Your ref:  
My ref: P20/00882

Date: 26<sup>th</sup> January 2021

**48 Berwick Street, London, W1F 8JD,**

**External alterations including installation of replacement glazed roof lantern, rooflights and replacement canopy. Erection of new external staircase. Installation of replacement door and windows at first floor level to rear. Internal alterations including the addition and removal of partitions.**

Project Title 48 Berwick Street, Soho, London W1F 8JD		Job No 3103
Drawing Title Existing First Floor, Second Floor and Third Floor Plan	Drawing No 03	Revision A
Date 25.11.19	Drawn by LL	Checked by DA
Scale 1:100 @ A3	Note

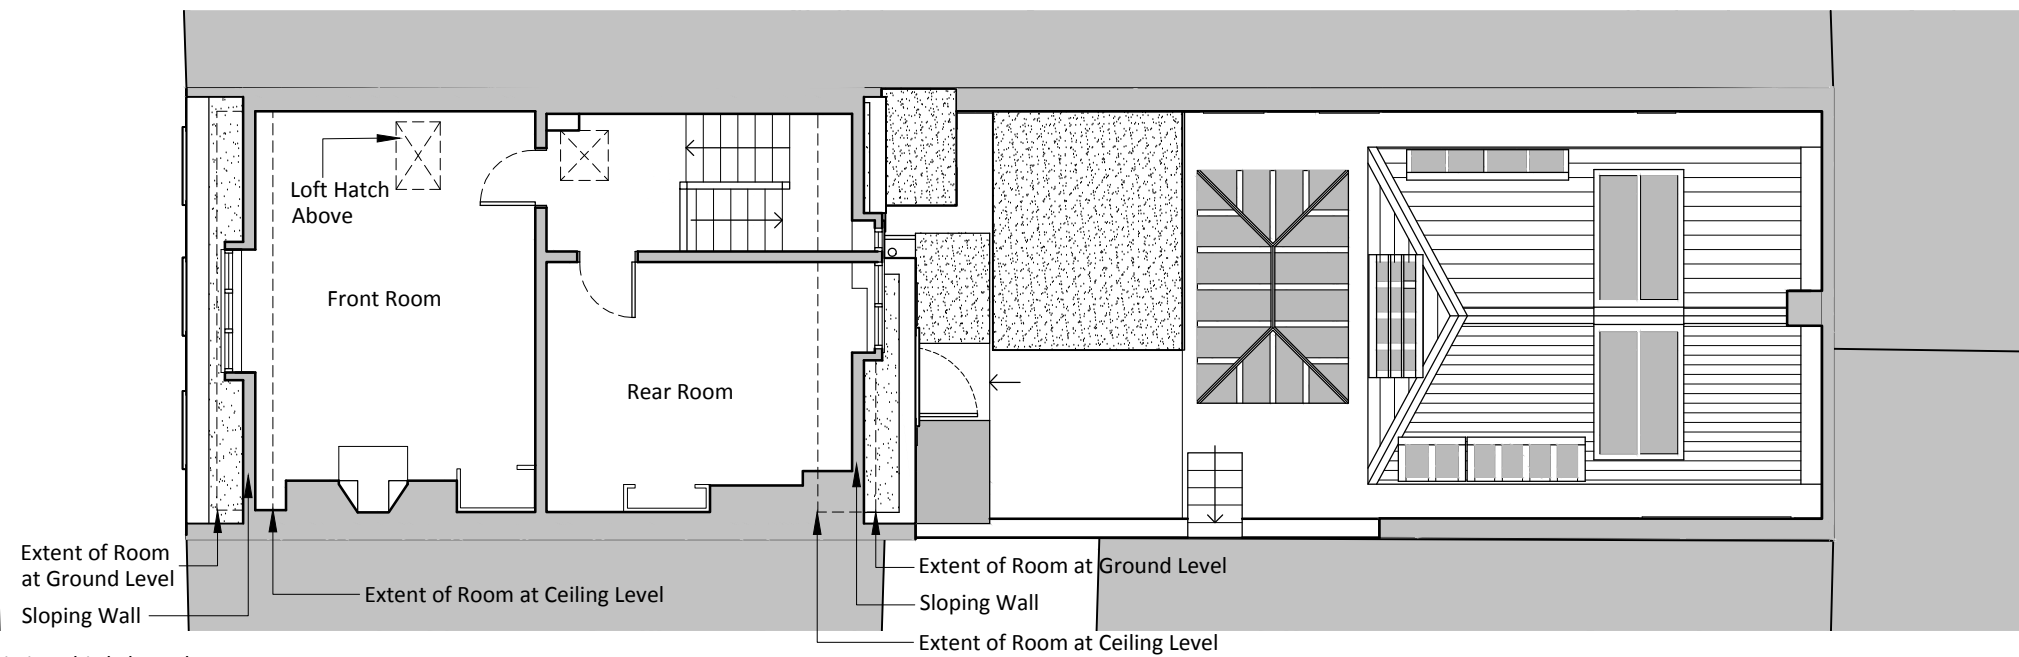
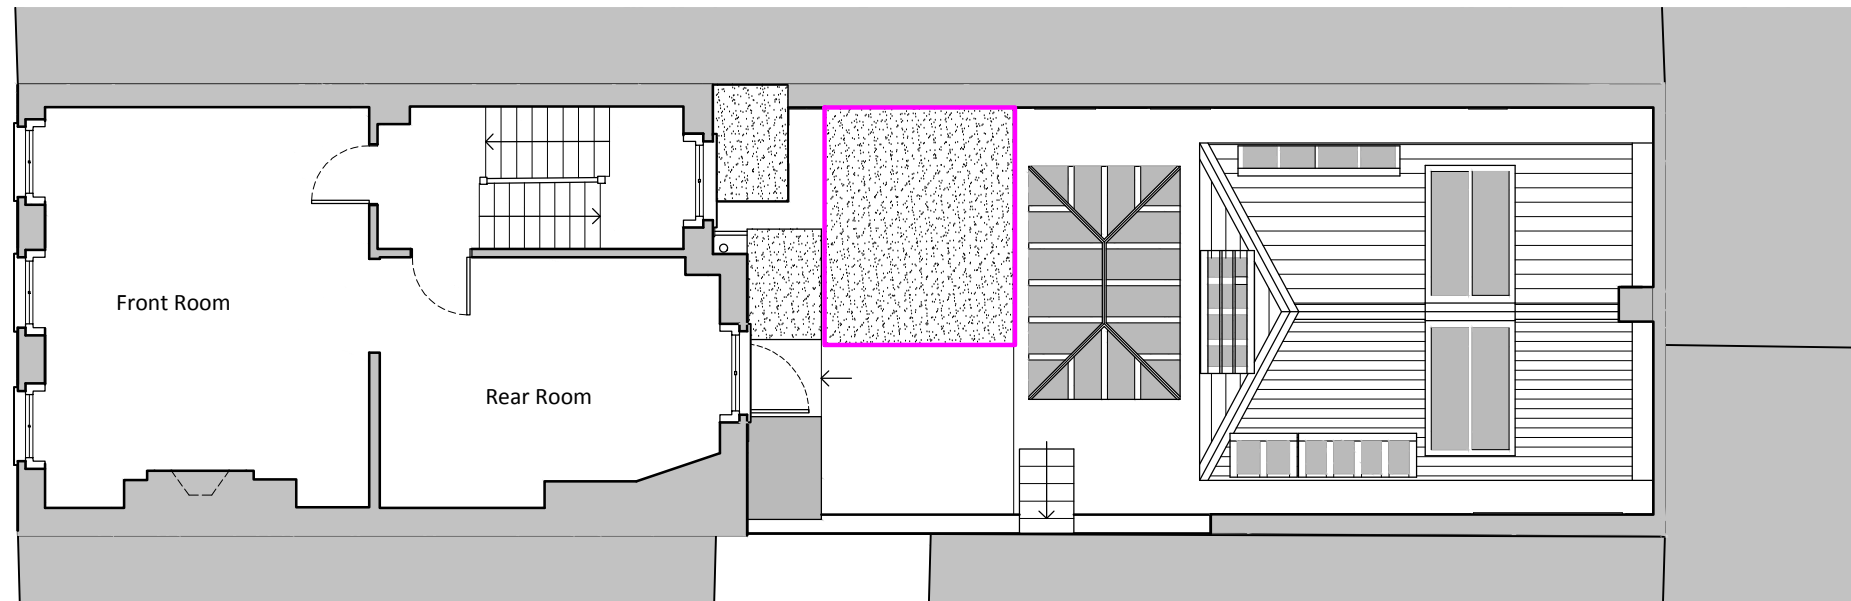
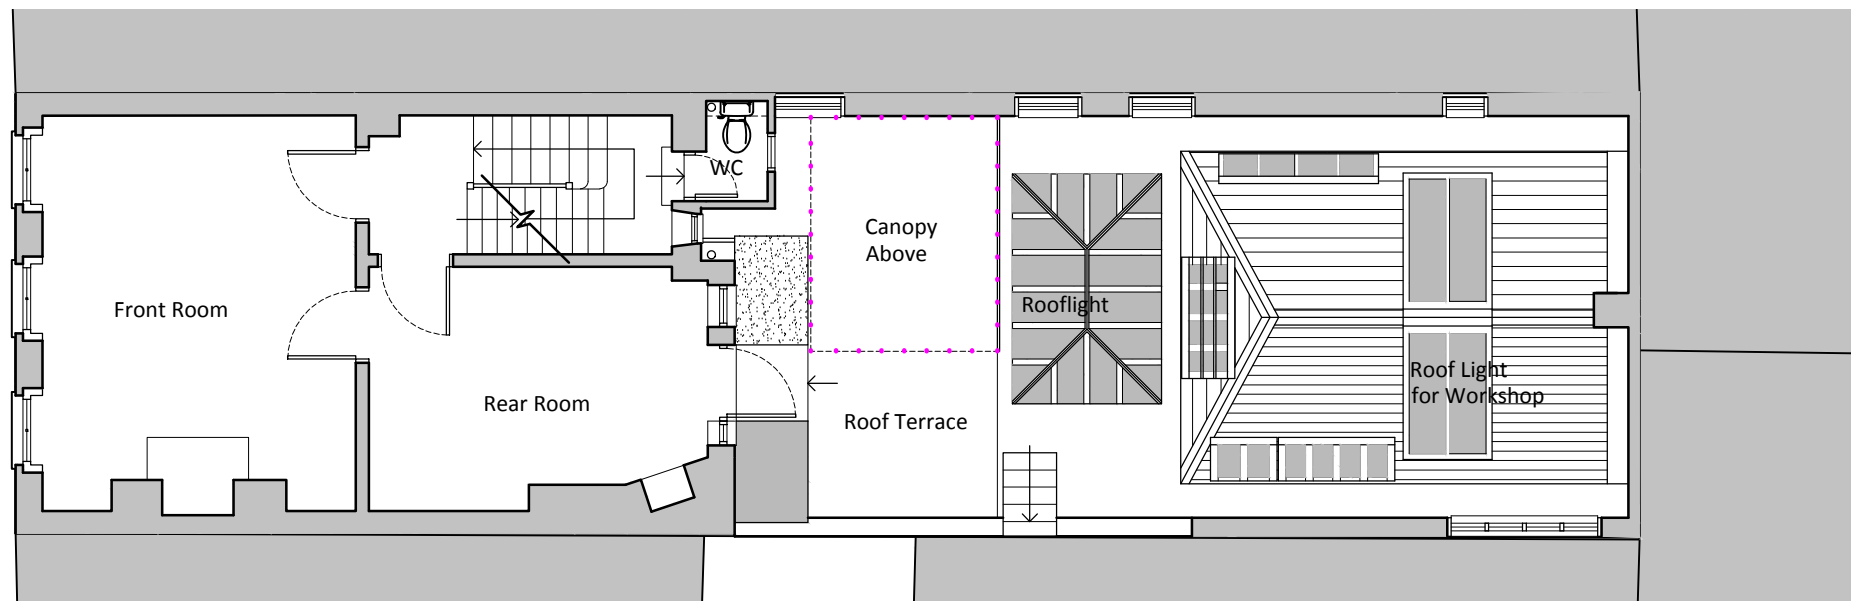
The existing canopy was in place prior to the building's listing, however, its appearance is unsightly, and its removal welcomed. The proposed metal canopy forms an unusual and dominant feature on the rear of this modest terrace. It is likely that no canopy is going to be considered acceptable here.

| Drawing Title Ground Floor Rear Roof Detail | Drawing No 10 | Revision - |

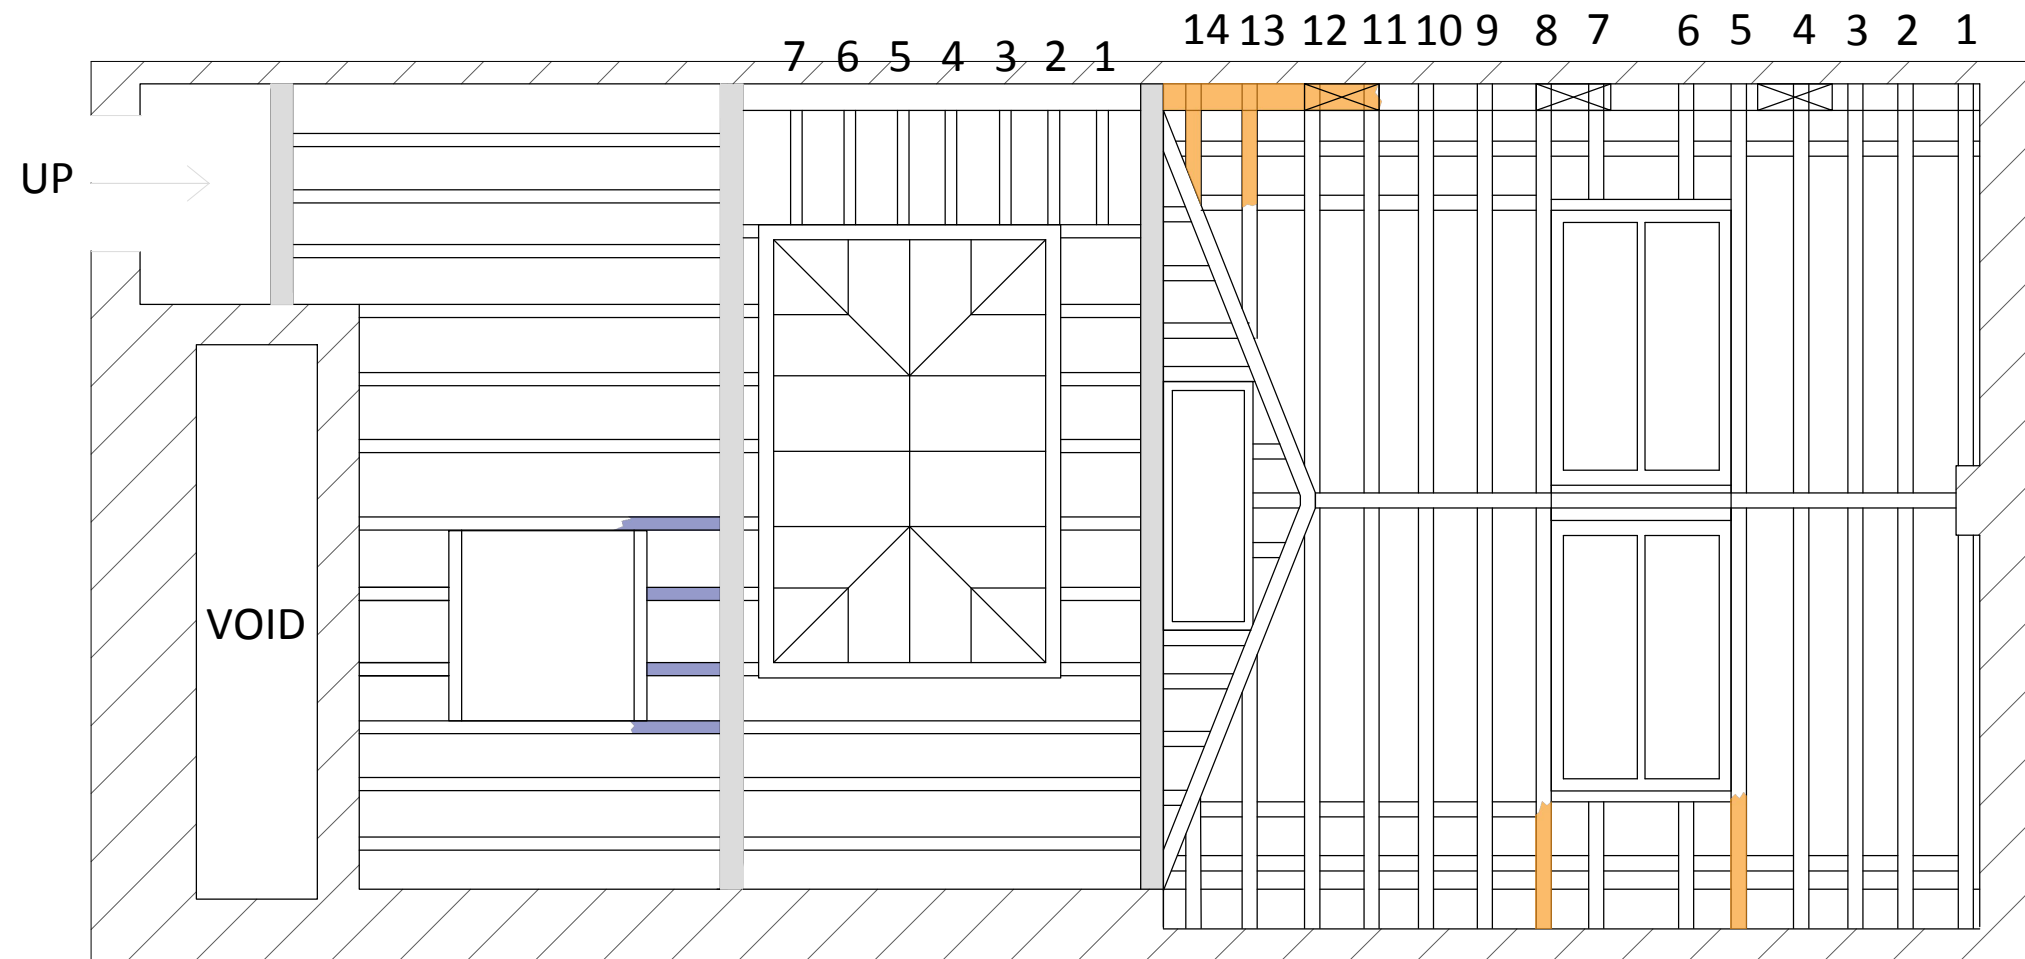
Upon a site visit it became clear that the roof of the rear workshop survives in a poor condition. Extensive repair works may be justified subject to the submission of a structural report and detailed drawings. The replacement of the roof lantern is likely to be acceptable if the proposed replacement is 'like for like' in material and design, a slimline double-glazed timber unit could be justified to provide better sound proofing. The removal of the roof covering and replacement with lead and slate is likely to be acceptable. The addition of natural insulation may also be acceptable. Drawings will need to be provided regarding the repairs to the timber frame below.
